WA/75/22/DOC

A proposed drainage strategy for the whole site and some detailed information has been provided. As has a verification report for a first phase of development (installed).

At this time, we **do not** recommend discharge of conditions until the following has been provided:

Non SE orifice plate
discharge details
(North, East, SW).

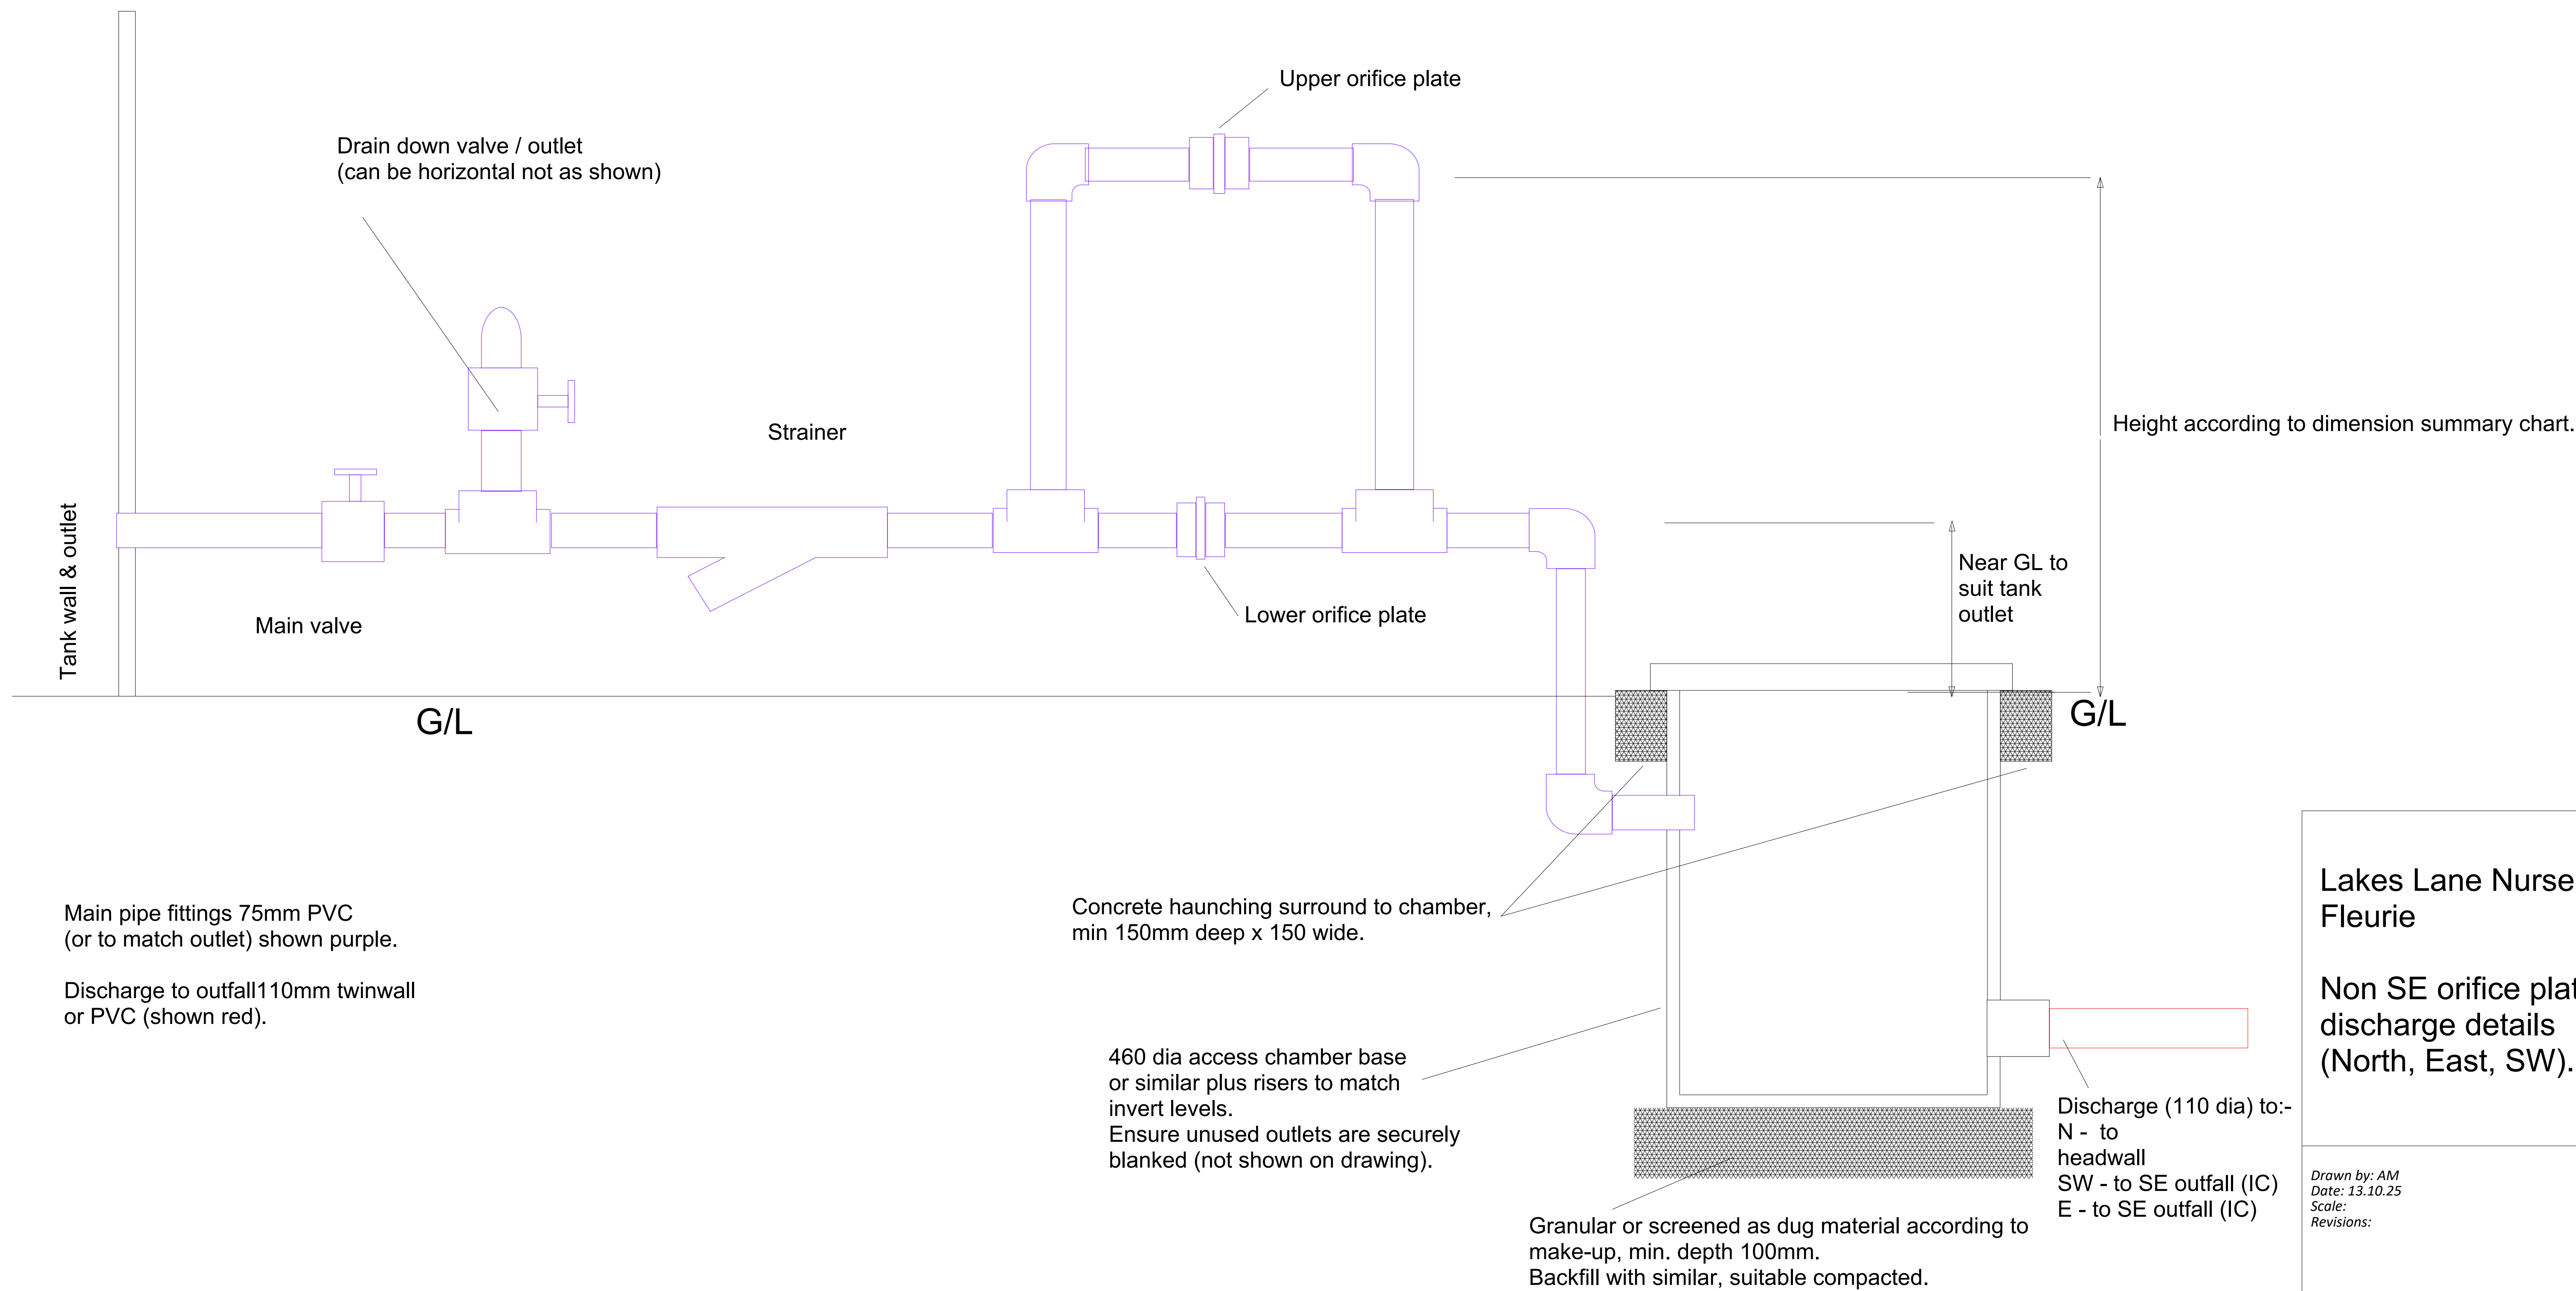
- The upper orifice plate will not activate when the tank is filled by rainfall events less than the 1:30 year storm (i.e. it is only activated for higher return period rainfall events). This requires calculations confirming the water level within each tank at intermediate return periods including the 1:1, 1:10, 1:30 and 1:100-year storms.

- The proposed orifice diameters are (in some cases) smaller than 50mm. The applicant should provide details to demonstrate how silt and other materials, that could block the outfalls, will be prevented from entering the storage tank.

Construction details v2

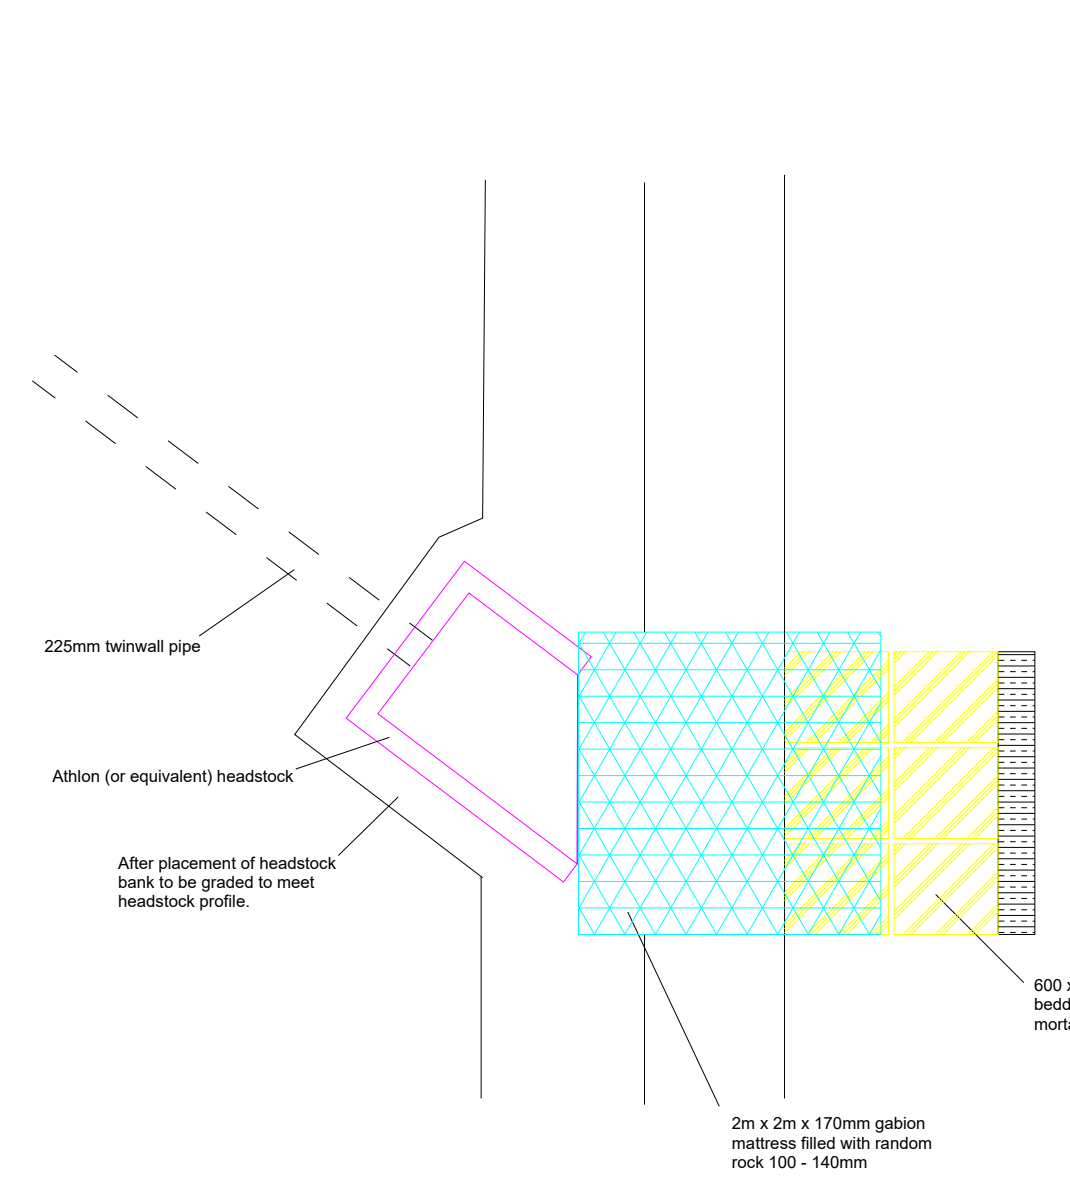
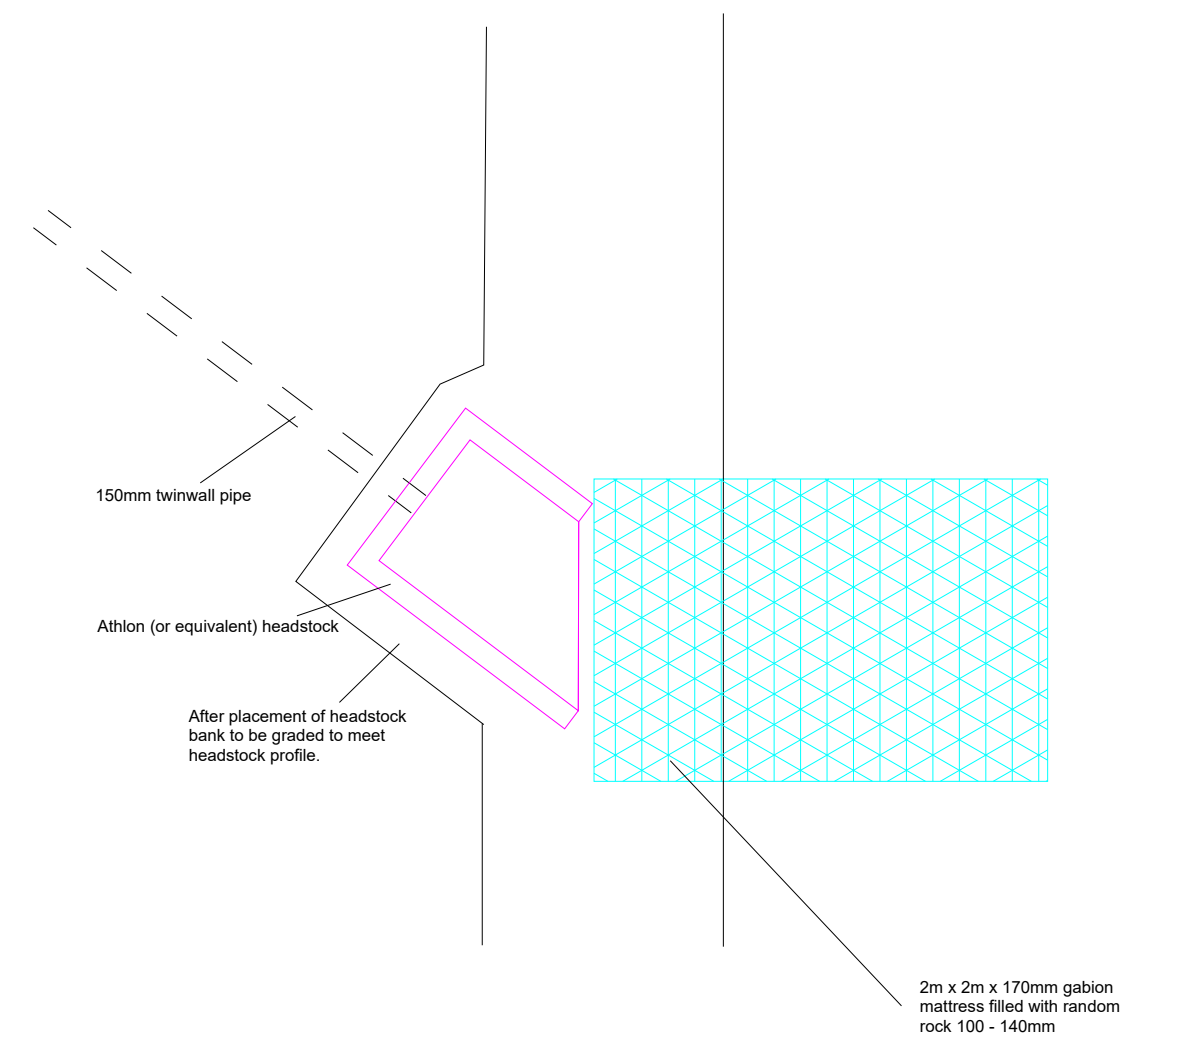
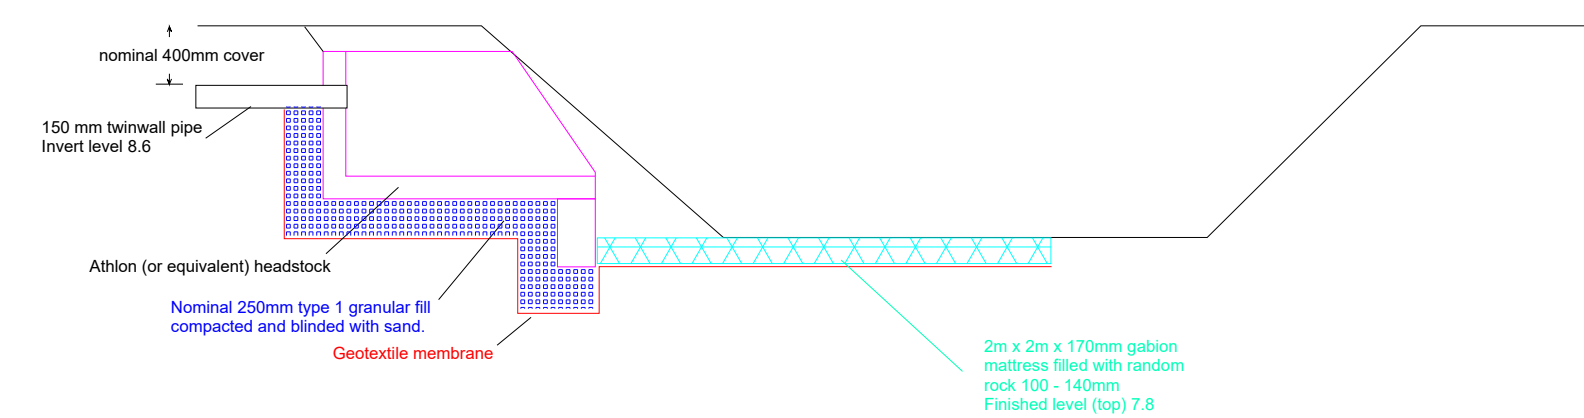
- Full construction drawings in addition to the product specific schematics provided.
 - Details of the pump.
 - Drawings of the outfall from the tanks must be provided, this should include a cross section / long section showing the tank in relation to the sump pump (for drain down) and the flow control devices (orifice plates), and outfall. It is currently unclear how the orifice plates relate to the sump / pump system and thus there is uncertainty whether the pumped runoff could enter the ditch during an extreme rainfall event.

- Ground levels, invert levels, and cover levels must be provided on the drainage drawings.
 - Technical drawings for the outfall(s) must be provided.
 - 6) A flap valve on the outfall(s) must be provided (to prevent backflow of water from the ditch network(s) entering the drainage system)

- It appears from the photographs included with the application, that an outfall has been constructed in contravention of the Land Drainage Act 1991. The applicant should be aware that Land Drainage Consent is required prior to outfalls being constructed and cannot be issued retrospectively. Drawings of the constructed outfall must be provided so that our Land Drainage Consent (LDC) team can review these and ensure there are no issues with the design. Furthermore, the LDC team may request an onsite meeting or inspection to review the unconsented outfall and any works in and around the existing ditches. We cannot recommend discharge of conditions until the LDC team are satisfied that no further changes to the outfall are required. For any new outfalls (as part of future phases of development) the applicant should apply for consent prior to construction, in accordance with the Land Drainage Act 1991.
